From: Simon Davis
Sent: 14 June 2021 13:41
To: 'Grace Palmer' [REDACTED]
Subject: RE: Planning Consultation on: BN/54/21/DOC

Application ref: BN/54/21/DOC

Description: Approval of details reserved by condition imposed under ref BN/50/20/PL relating to Condition Nos 5 - mitigation method statement, 6 - archeaology, 7 - piling risk assessment & method statement, 8 - Construction & Envirmental Management Plan, 9 - foul drainage, 10 - surface water drainage, 11 - maintenance & management of surface water drainage, 13 - pre-commencement site meeting, 15 - odour assessment or evidence that livery has ceased, 16 - soil resource plan, 17 - landscaping, 18 - screen walls & fences, 19 - elevation details of 2 proposed communal bin stores and 20 - colour schedule of materials & finishes.

Location: Land Rear Of 1 Northfields Cottages Fontwell Avenue Eastergate PO20 3RX

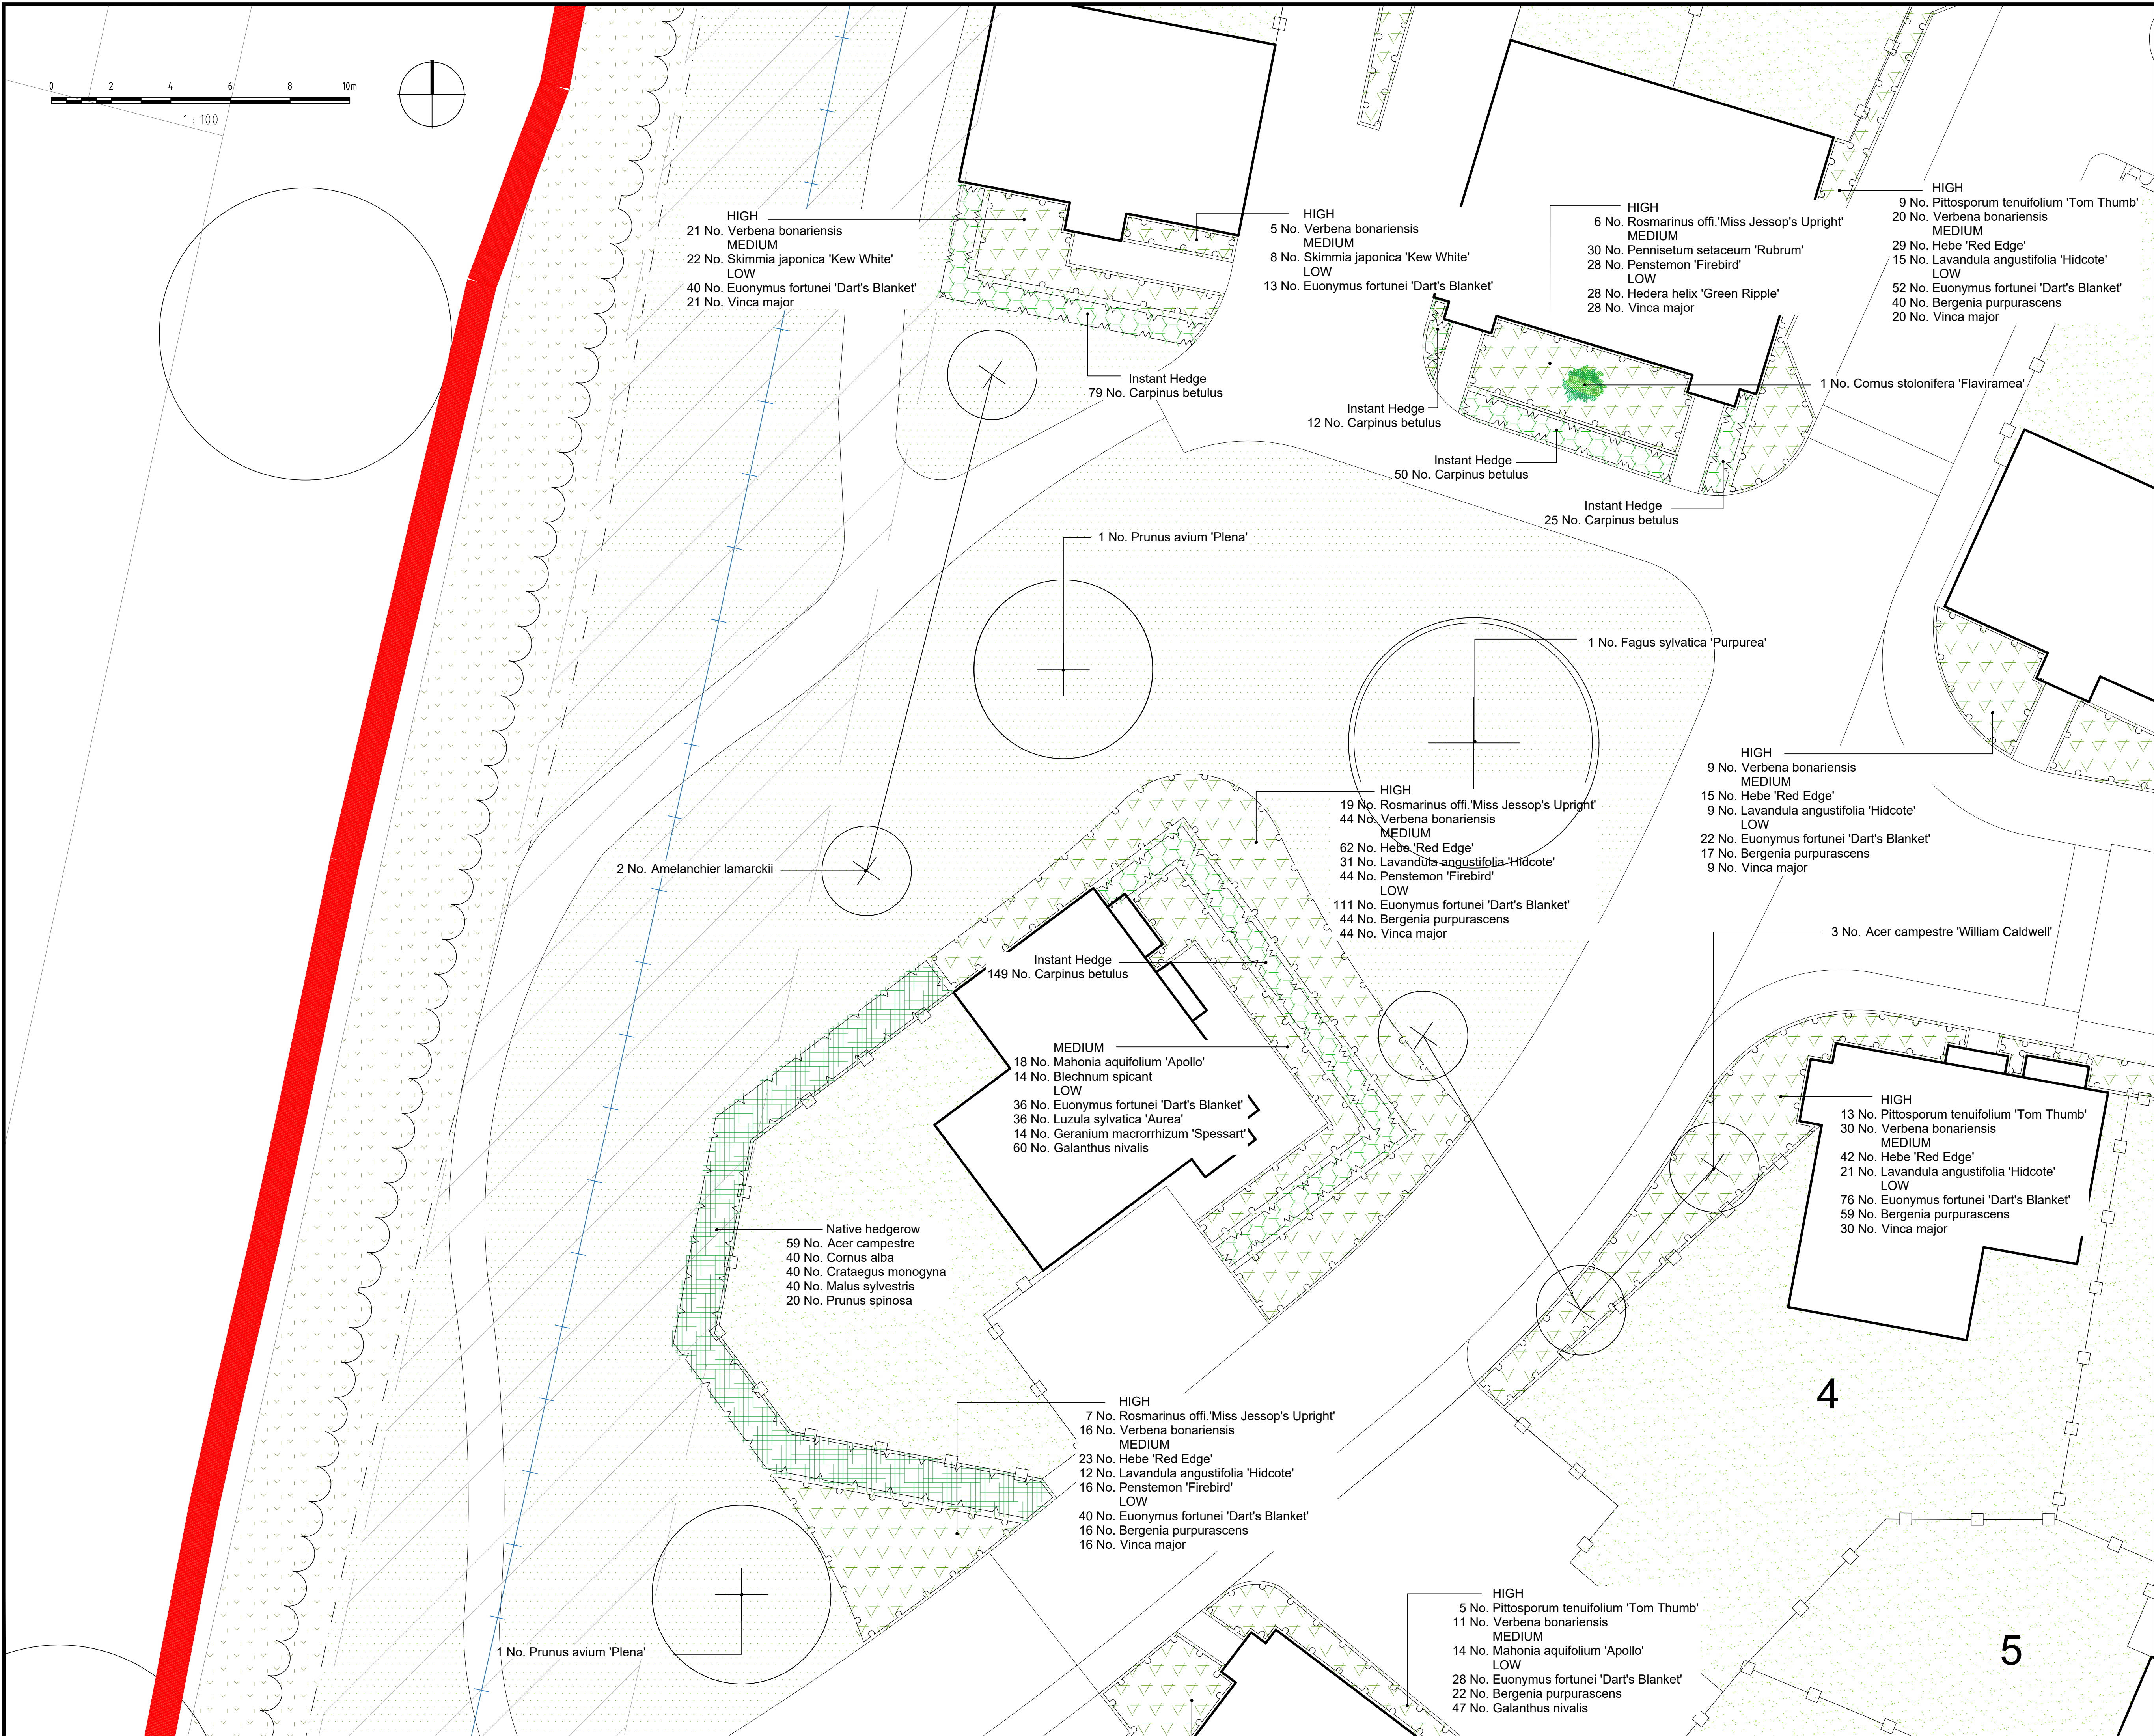
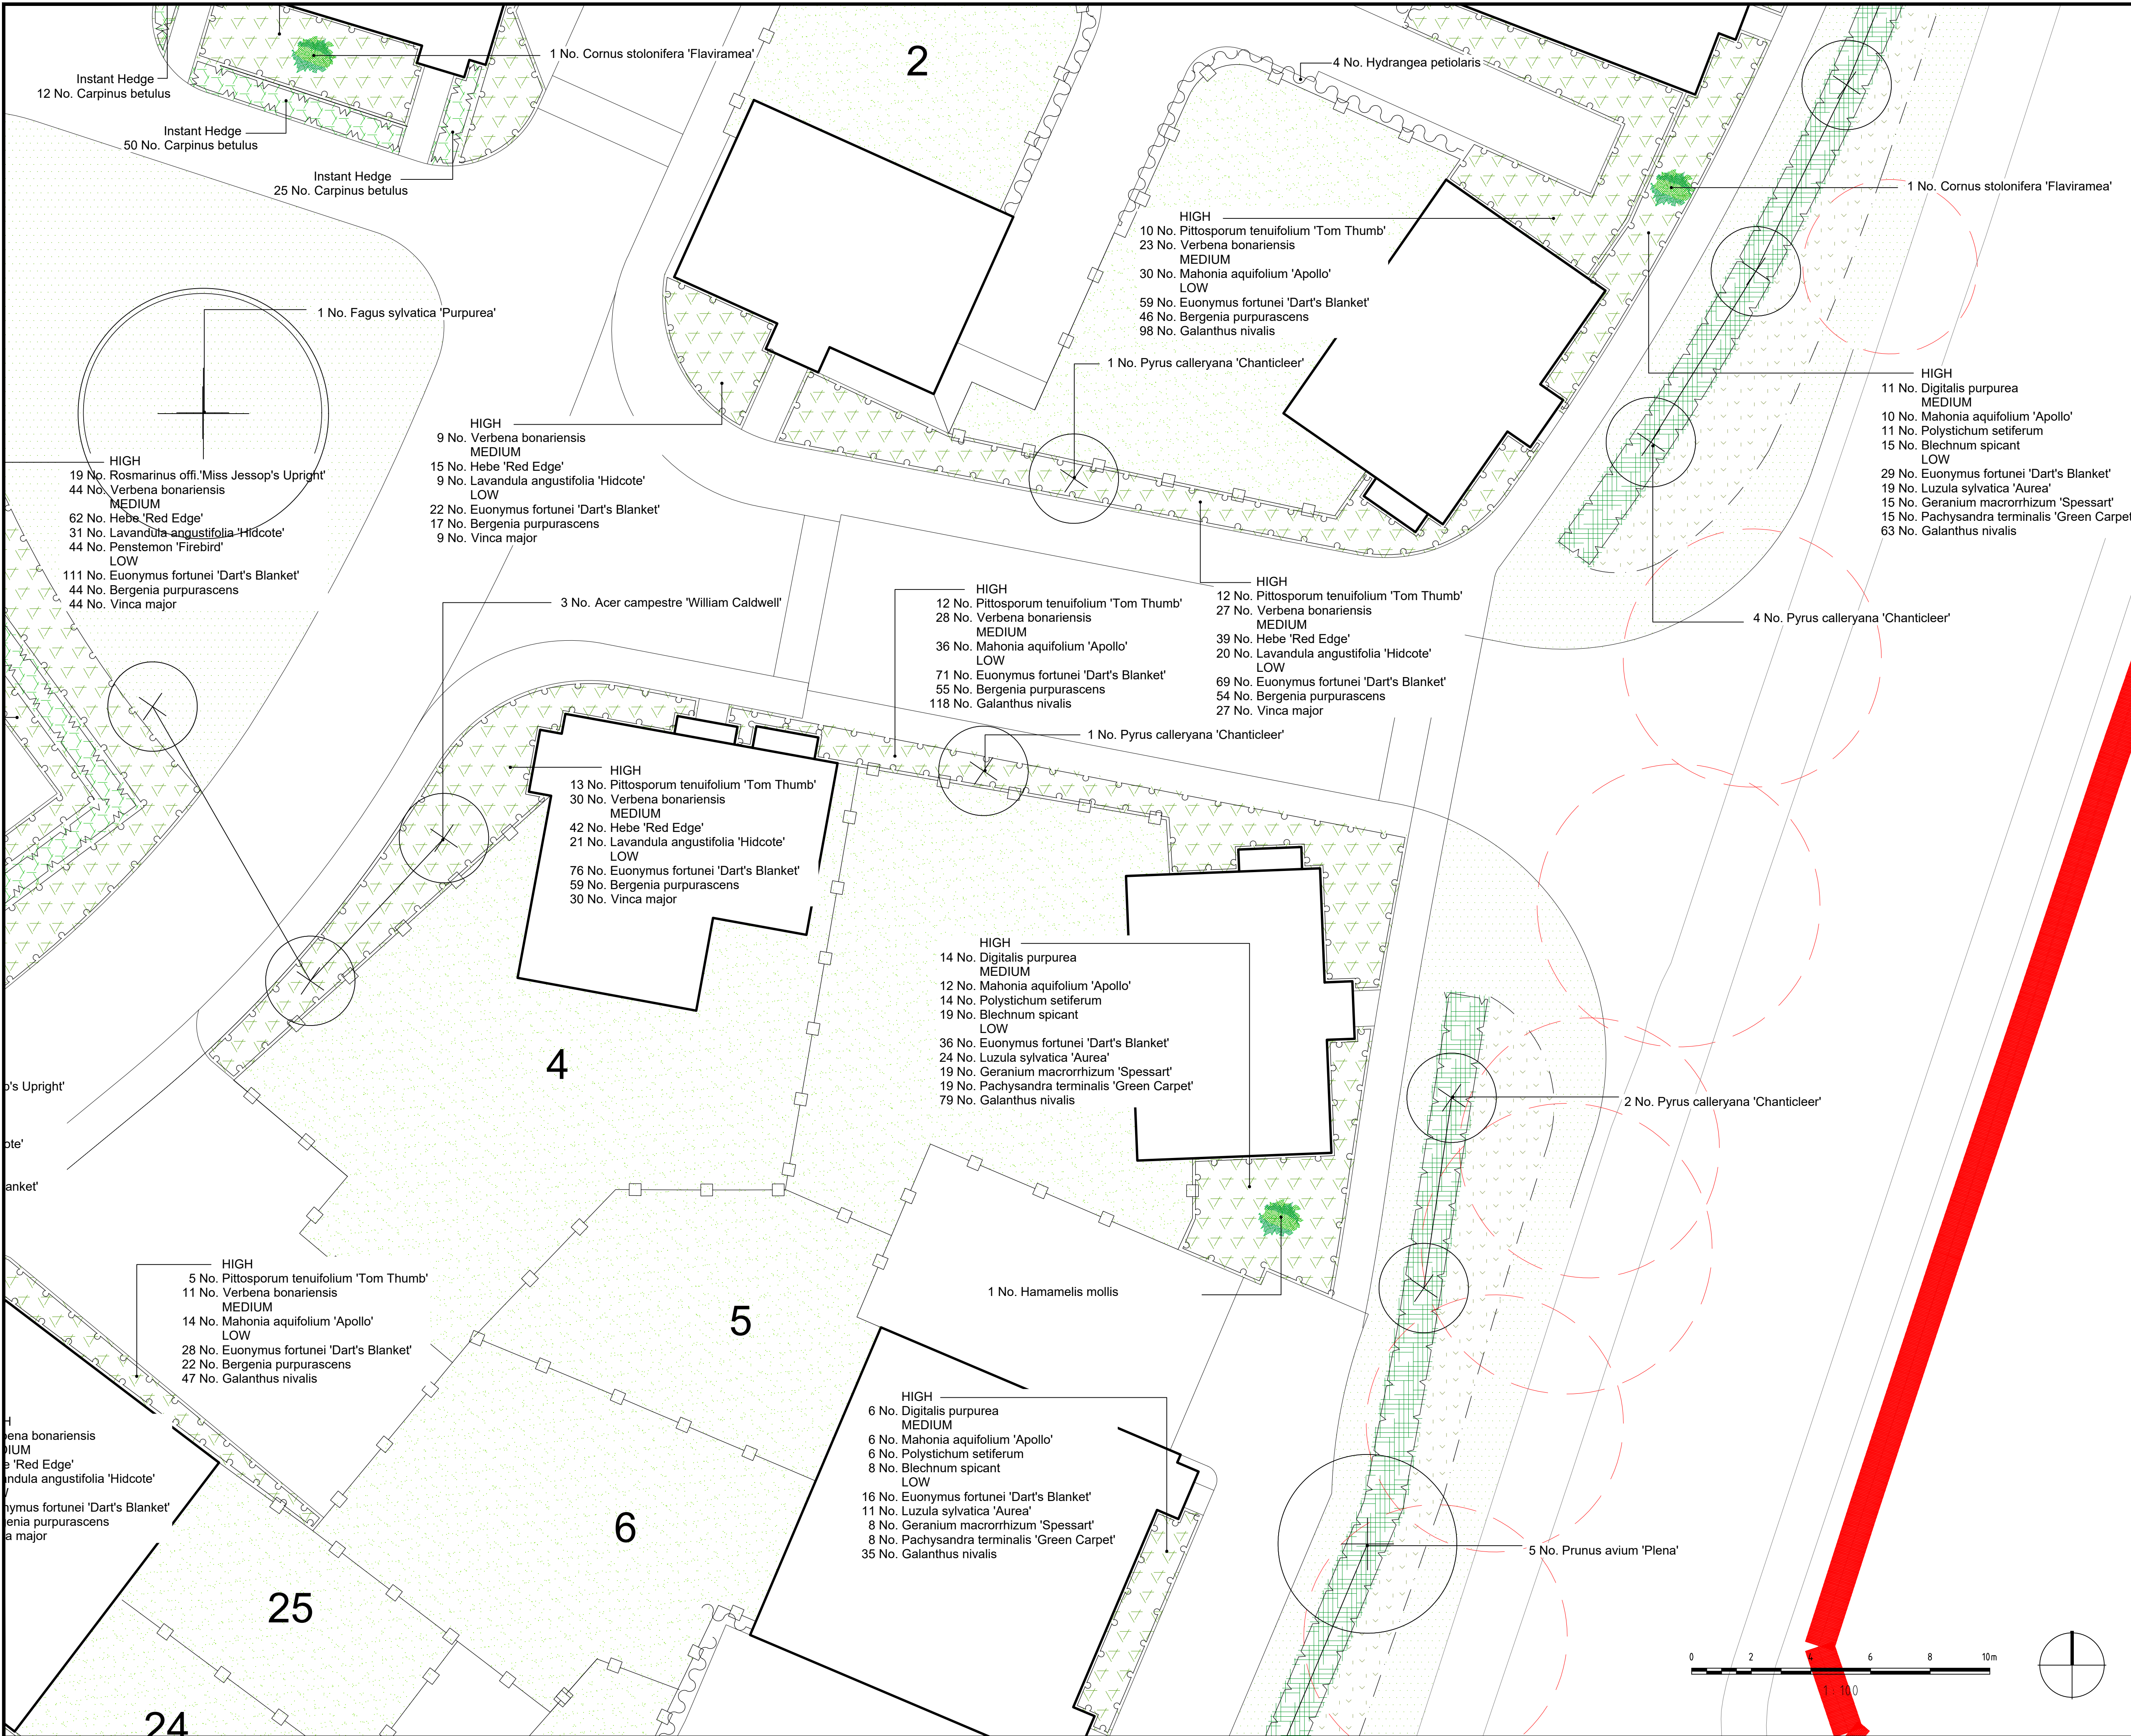
The proposed landscape detail specified in Detailed Planting Plans 1-8 L01- L08 and Coloured Masterplan dwg D2776-FAB-00-XX-DR-L-1000 Rev PL02 have proposed a scheme which would be fitting for location and contains detail including species choice, quantities being proposed, planting densities and size at time of planting.

There would not appear to be any drawings showing which detail the previously agreed play provision of timber fitness items into the POS areas to the n/west area of the site. The Coloured Masterplan dwg D2776-FAB-00-XX-DR-L-1000 Rev PL02 needs to reflect these items and location of these.

Summary recommendation: Recommend the discharge of Condition 17 Landscaping scheme on this application BN/54/21/DOC imposed under BN/50/19/PL, **subject to** the submission of additional drawing which shows the previously agreed play provision of timber fitness items into the POS areas to the n/west area of the site.
